Recommendation Report for Planning Permission for Works or Extension to a Dwelling

REF NO: A/8/20/HH

LOCATION: 16A Cumberland Road
Angmering
BN16 4BG

PROPOSAL: Construction of single storey front and rear extensions and conversion of garage into habitable accommodation.

PROPOSED REAR ELEVATION

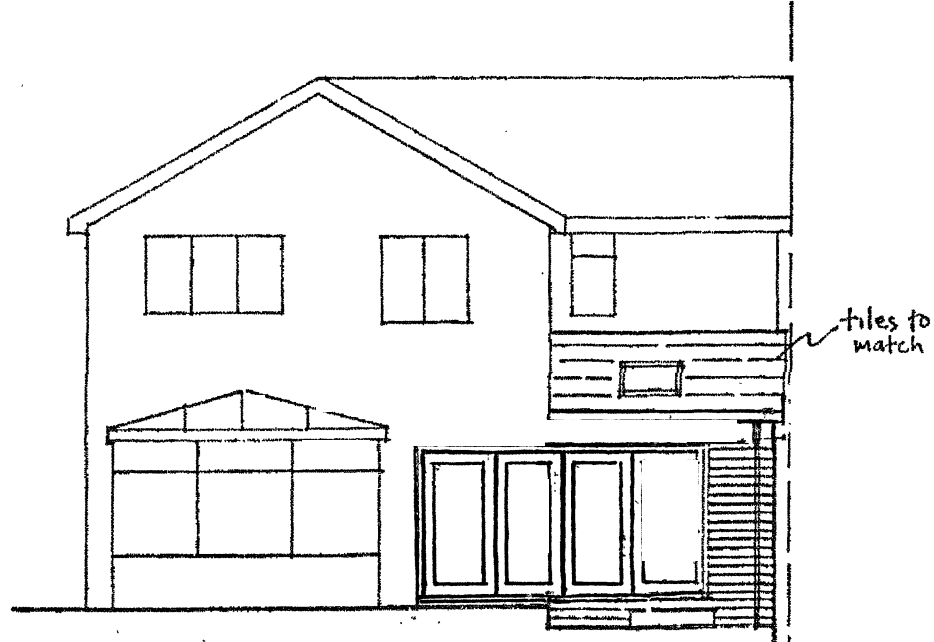
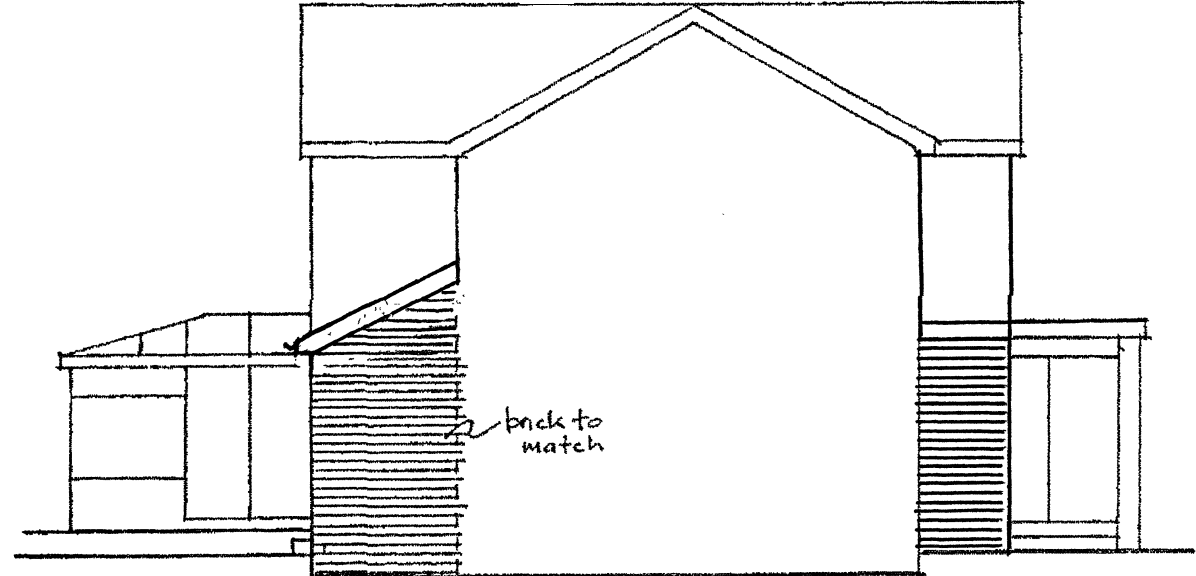
The proposed single storey rear extension will be located to the rear of the existing garage and will be situated in 16.785m from the eastern boundary of the site which is the rear garden of the neighbouring property. The application site is set higher than land to the north due to the sites topography. However, despite this the proposed dwellings is not considered to give rise to any unacceptably adverse overbearing or overshadowing impacts on neighbouring properties due to the distance between the development and nearest development.

Due to the proximity of the neighbouring properties to the rear it is considered that the proposed extension will not give rise to any unacceptably adverse overlooking beyond that which is already achievable at the site. Therefore, it is considered to accord with D DM1 and D DM4 of the Arun Local Plan.

The proposed garage conversion by virtue of its location will not give rise to any unacceptably adverse overbearing, overlooking or overshadowing impacts on neighbouring properties as there is an extension to either side of the garage. With no inclusion of windows on the northern elevation of the development there is not considered to have any unacceptably adverse overbearing, overlooking or overshadowing impact.

PROPOSED FRONT ELEVATION

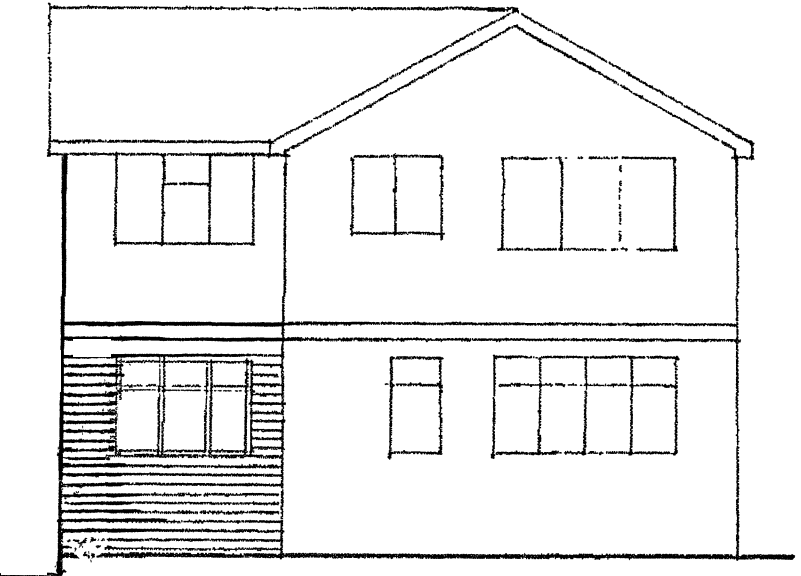
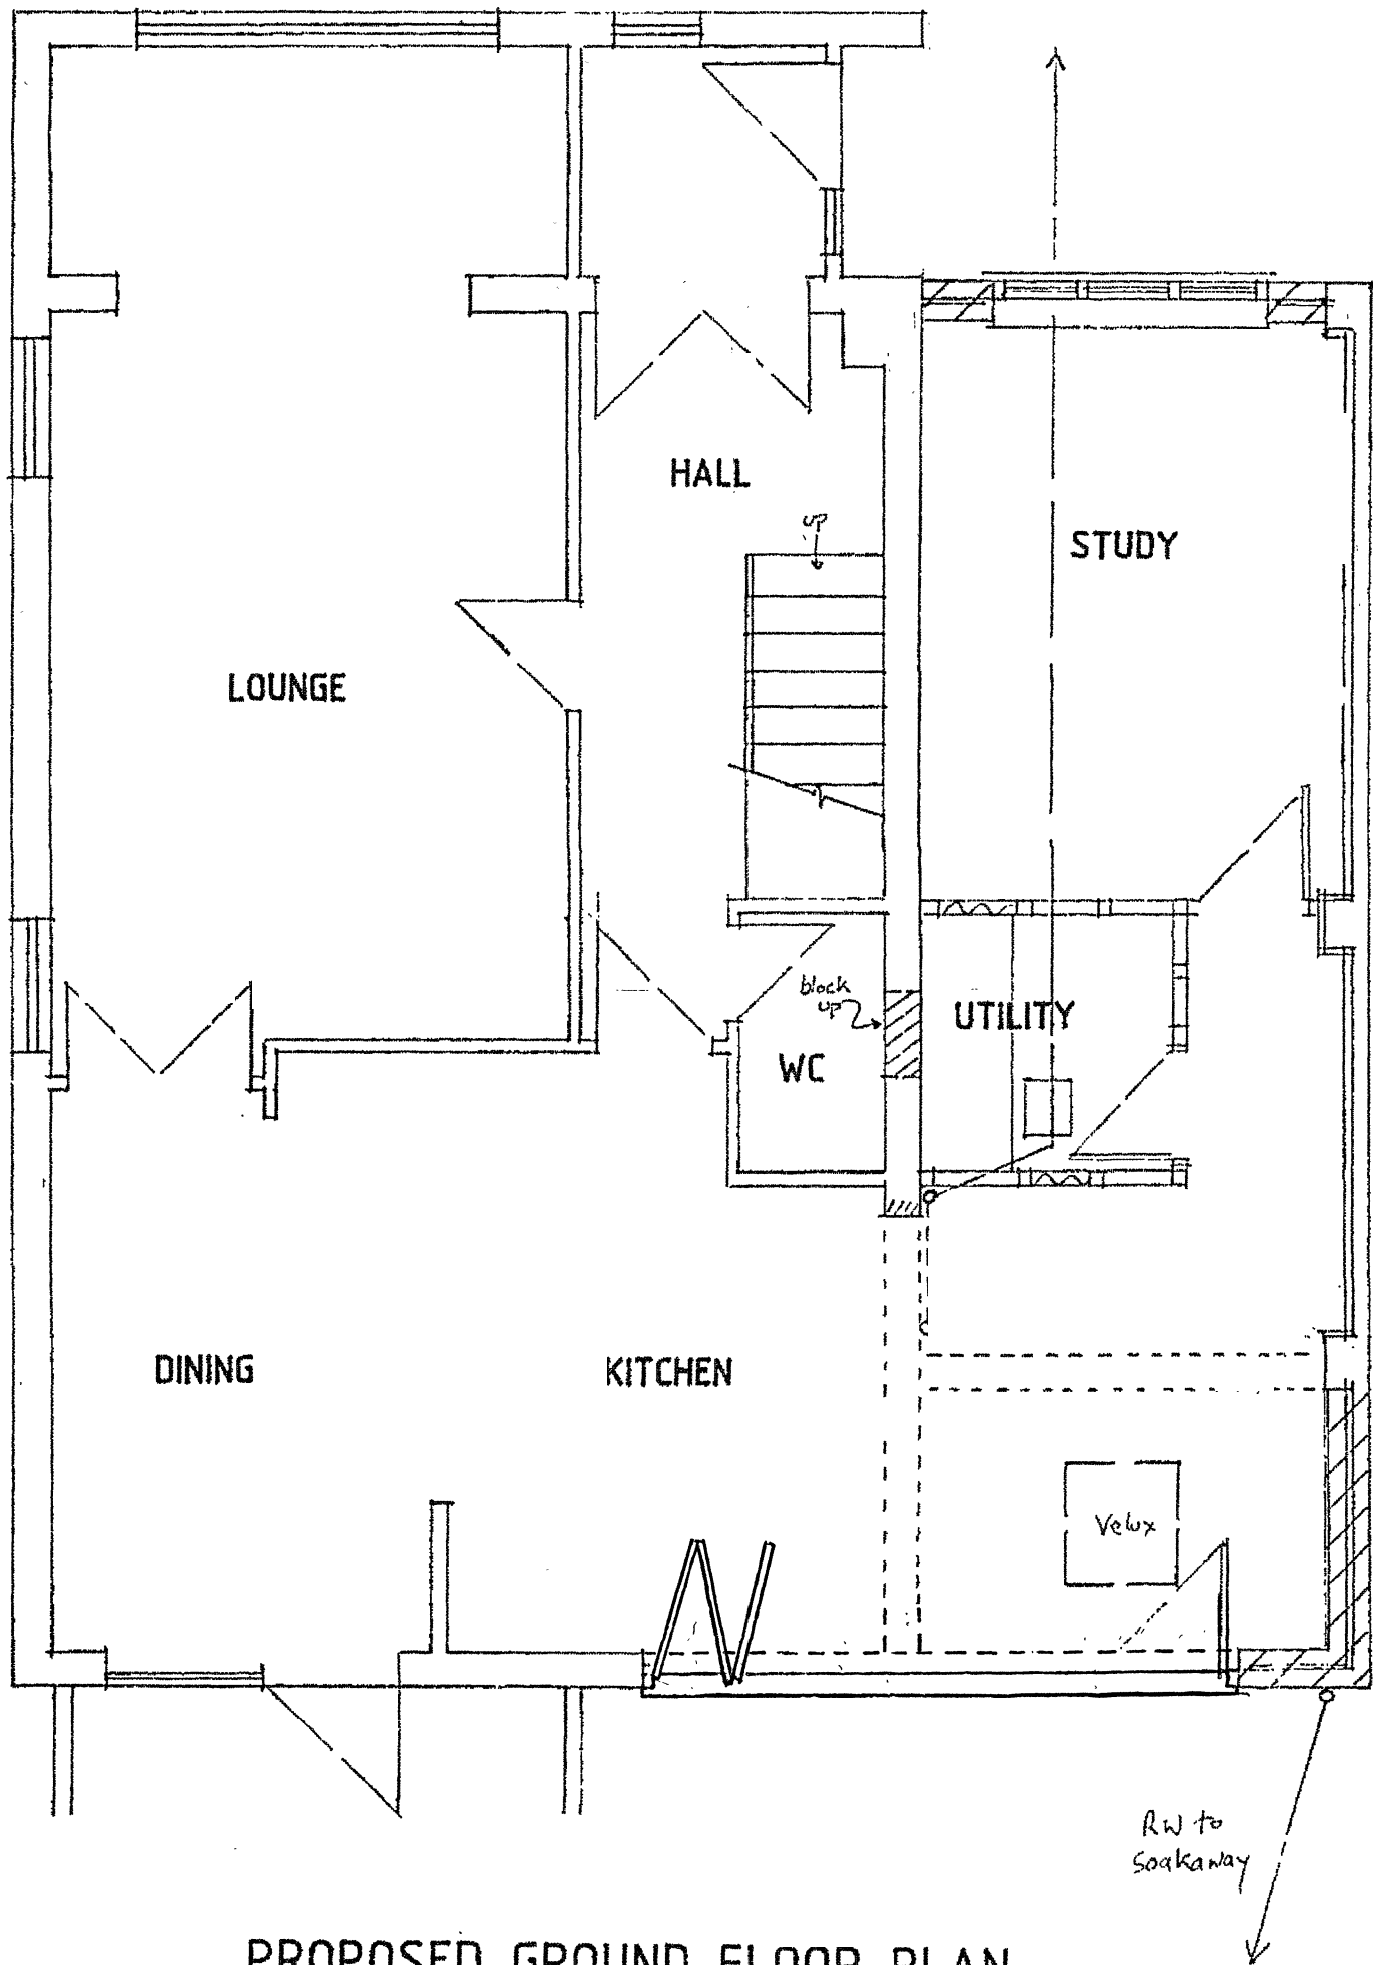
The proposal seeks a front extension which will be visible from the street scene. With further development to the rear in the form of another extension. The two extensions will be either side of the existing garage which the application seeks to have converted to habitable use. The driveway will provide off street parking for three vehicles which is considered sufficient given the size of the dwellinghouse.

It is noted the proposed garage conversion to habitable use falls under section 55 of the GPDO and as such would not need approval from the Local Planning Authority. The proposed single storey rear and front extensions by virtue of its size and location is not considered to have an adverse impact upon the spatial pattern of the street scene in accordance with D DM1 and D DM4 of the Arun District Local Plan and policy HD5 of the Angmering Neighbourhood Plan.

The proposed extension is also considered to appear subservient and well integrated with the host dwelling by virtue and as such is deemed to accord with policy D DM1 of the Arun District Local Plan. The proposed development will be carried out using materials which match in appearance the original dwellinghouse as such the proposal is not deemed to conflict with policy HD4 of the Angmering Neighbourhood Plan. The development due to the siting and design accords with DDM1 and DDM4 of the Arun Local Plan.
